31 Fore Street BP# 2016600916

1 FLOOR PLAN - GARAGE/BASEMENT
 SCALE: 1/4" = 1'-0"

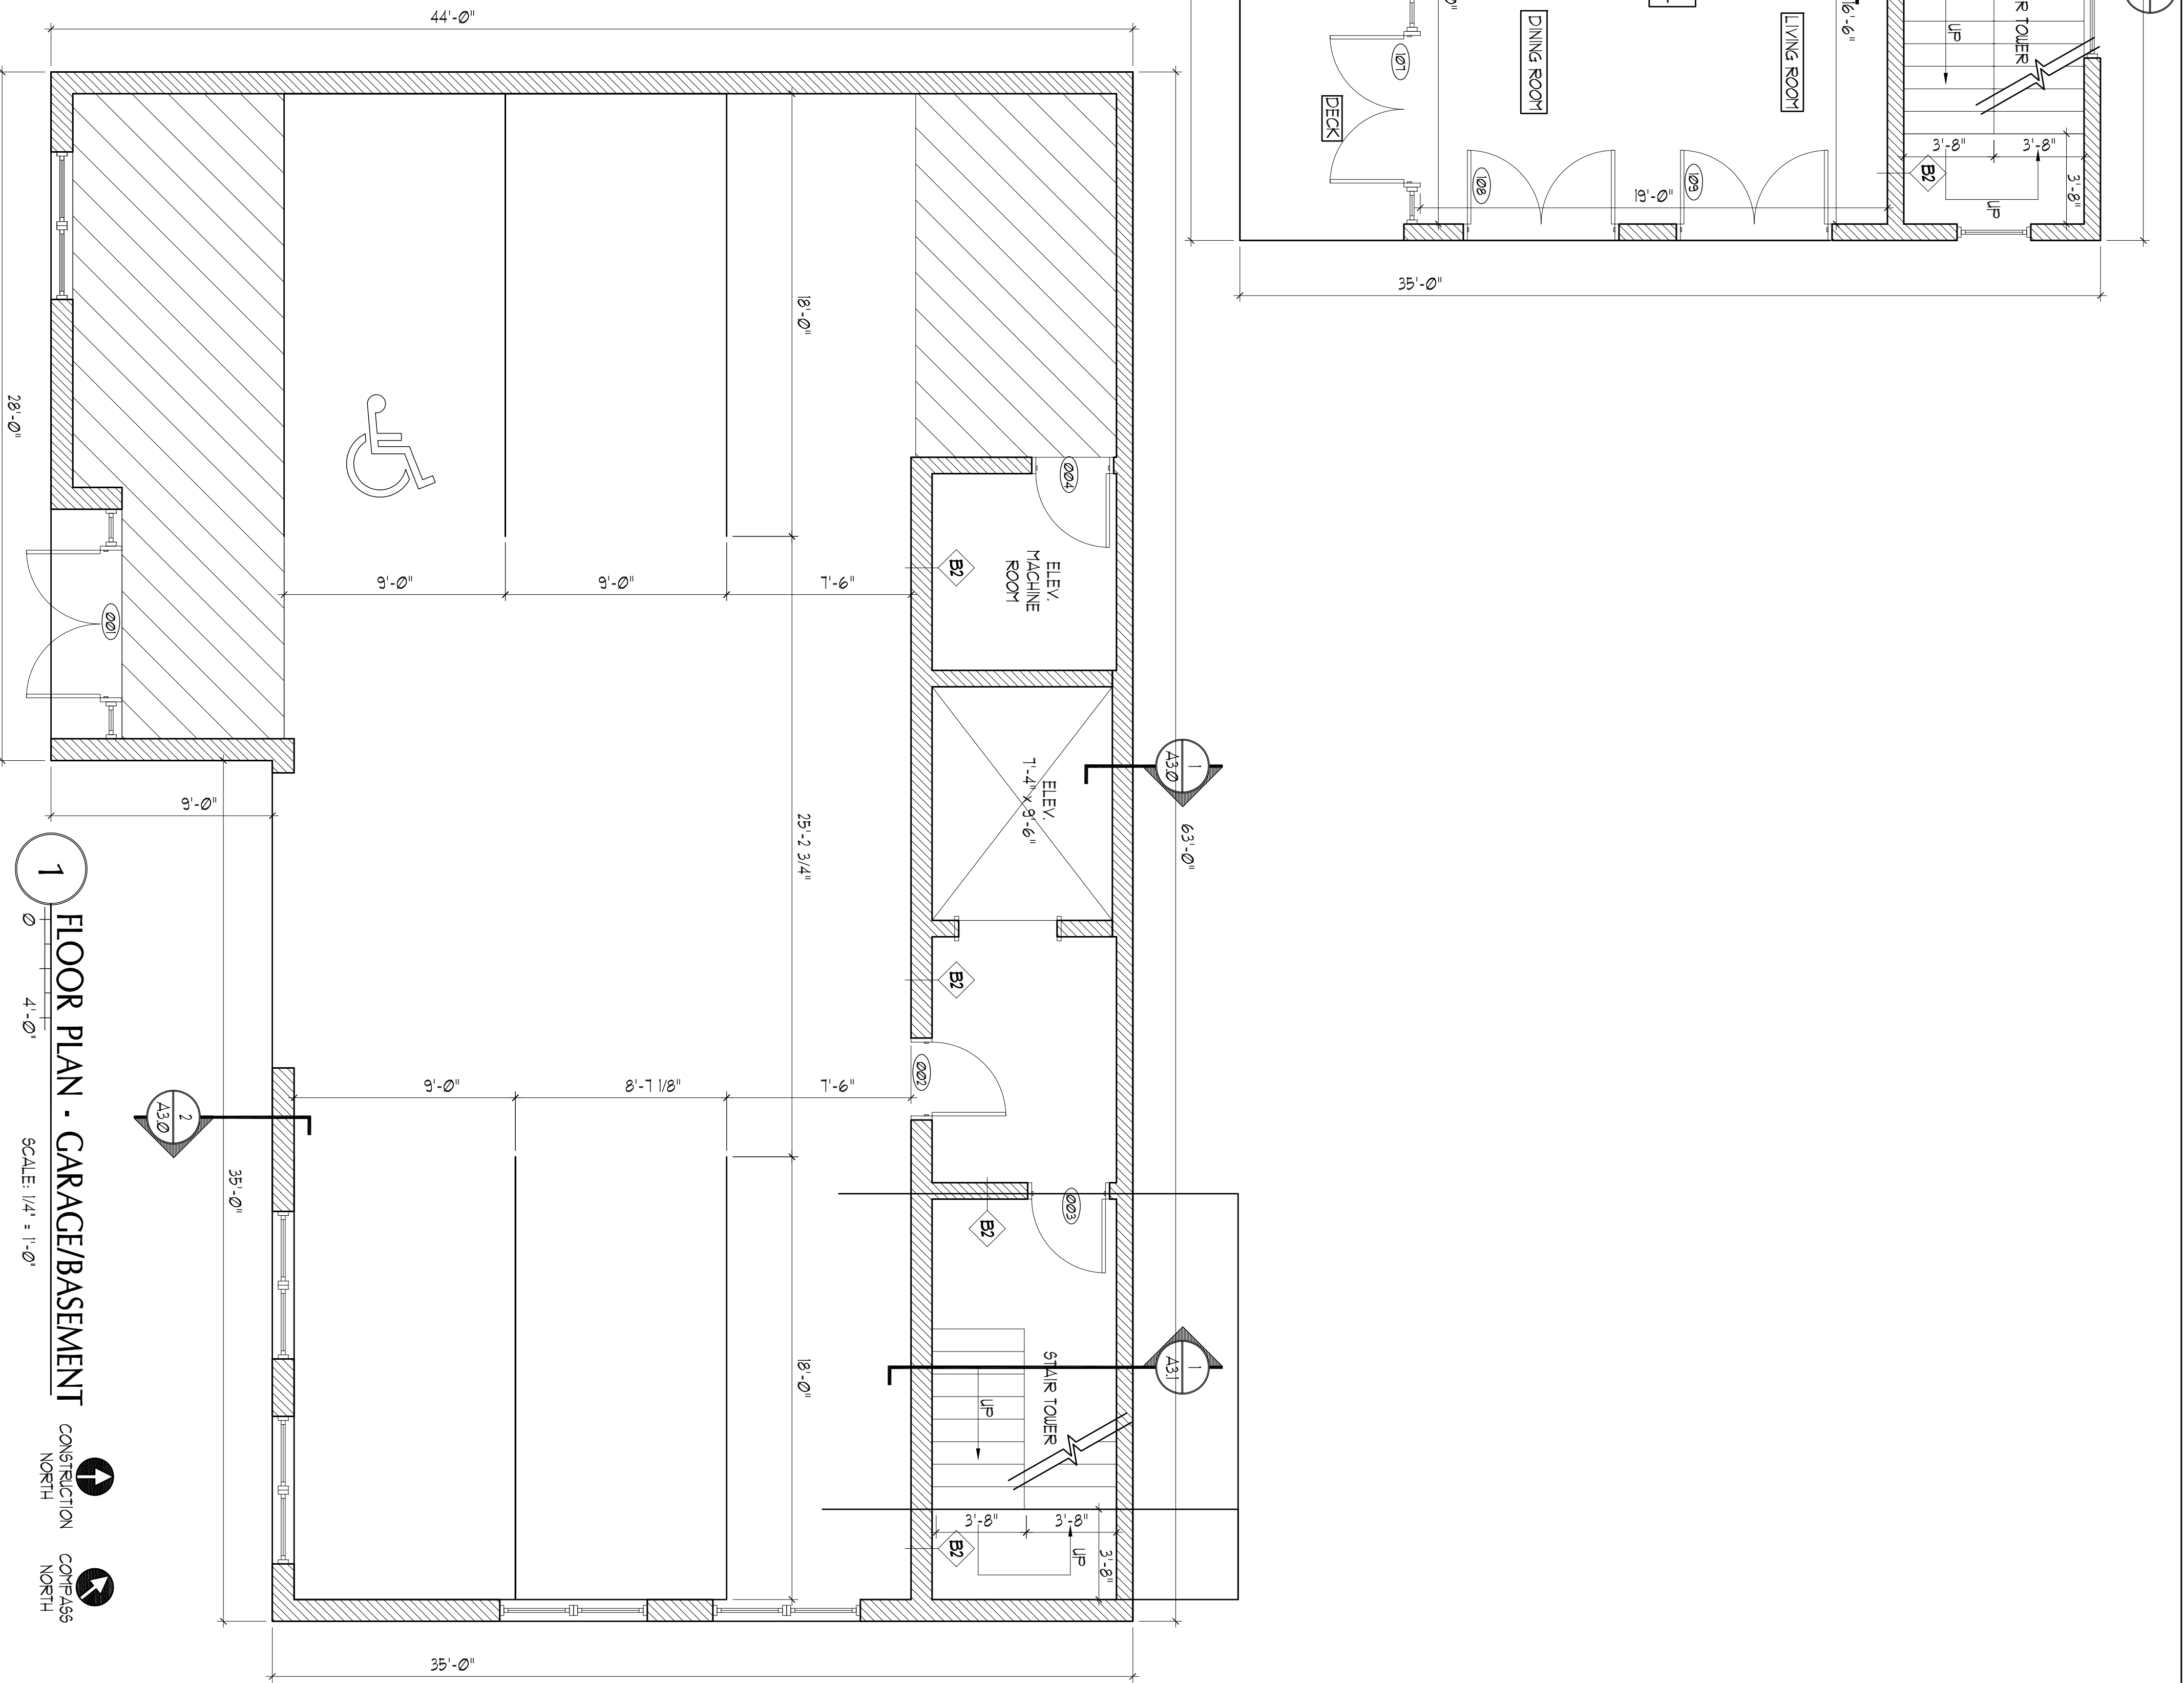
1. On the ADA parking space issue: The parking space is an ADA parking space as required. The space itself is 96" with a 60" aisle (it is actually 79"). The plan of that level is stamped by Andy Hyland (principal). Furthermore, on the Titlesheet of our submission, we state that this project meets ADA. Finally, as part of the Building Permit Application, we have signed and stamped the Accessibility Building Code Certificate. All three of these documents are attached to this email for your reference.
